# KITTITAS COUNTY

### MEMORANDUM

DATE: December 1, 2017

SUBJECT: Swauk Valley Ranch Conservation Plat LP-17-00007

**SHEET 1**

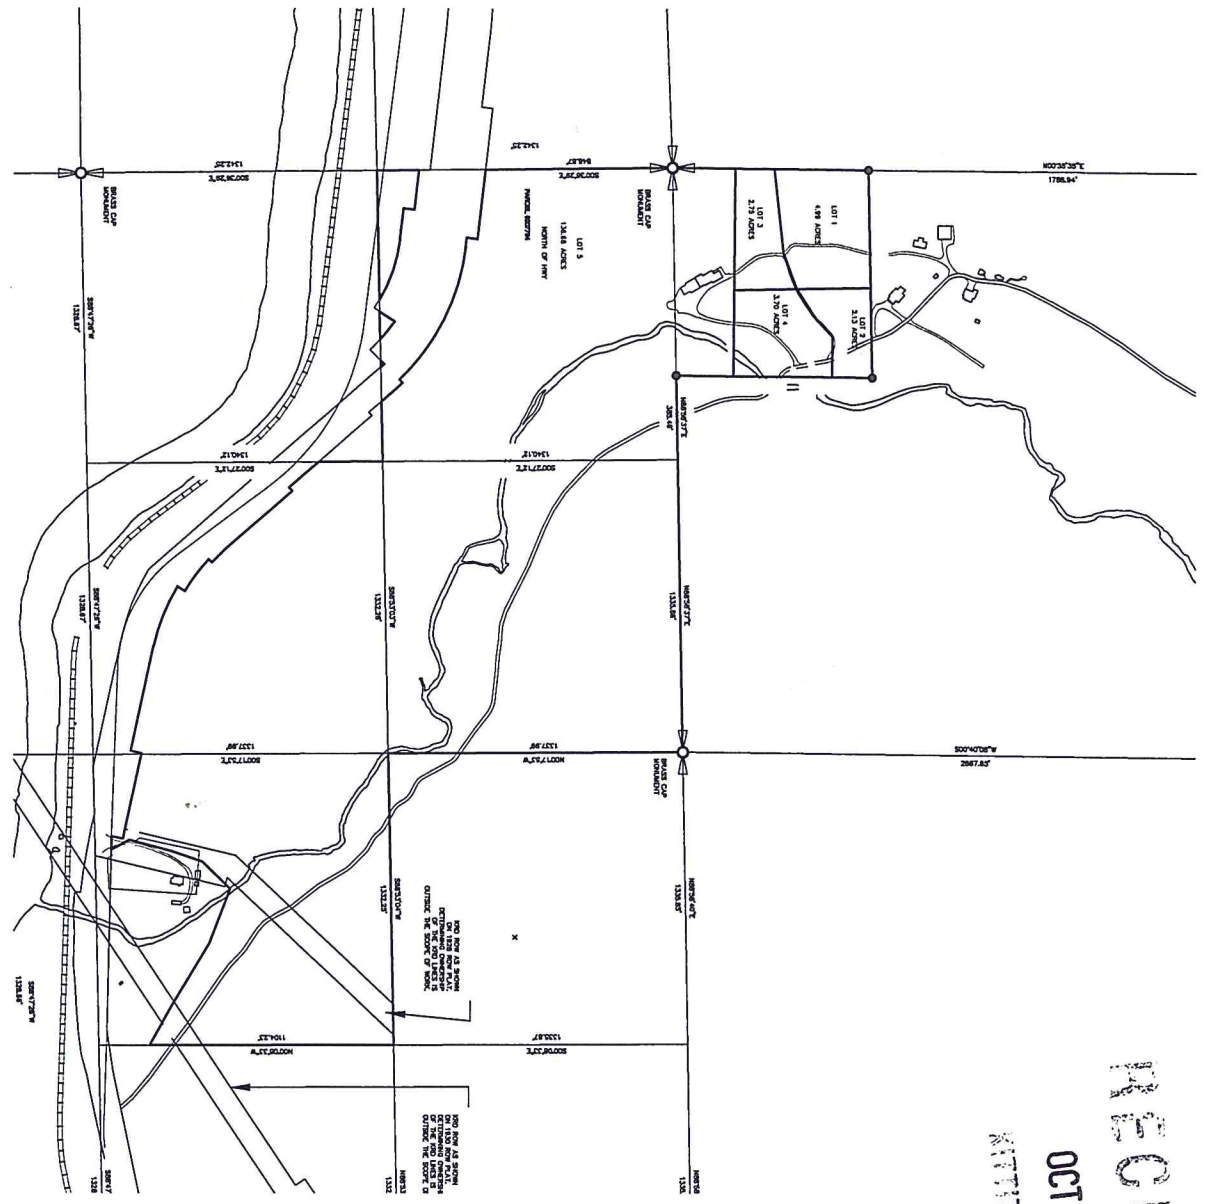
1. Washington State Department of Transportation: Provide copy of access approval/permit from WSDOT allowing for the change in use.
2. Private Road and Driveway Easements: The private road and driveway easements shall be clearly depicted on the face of the plat in accordance with the driveway standards as shown in the Kittitas County Code 12: section 12.04.080 table 4-4 Private Road Minimum Design Standards.

- A bond has been received by Public Works for the work to be performed.
4. Turnaround: When a road extends more than 150' from the centerline of a County road or other publicly maintained road or serves more than three lots, a turnaround shall be provided. The turnaround shall be a cul-de-sac for roads serving five or more lots/units. The turnaround may be a hammerhead for roads serving four or less lots/units or for a land use development activity occurring prior to the end of the road. Cul-de-sac and hammerhead designs must conform to the specifications of the International Fire Code. A cul-de-sac shall have an easement diameter of at least 110 feet and a driving surface of at least 96 feet in diameter.
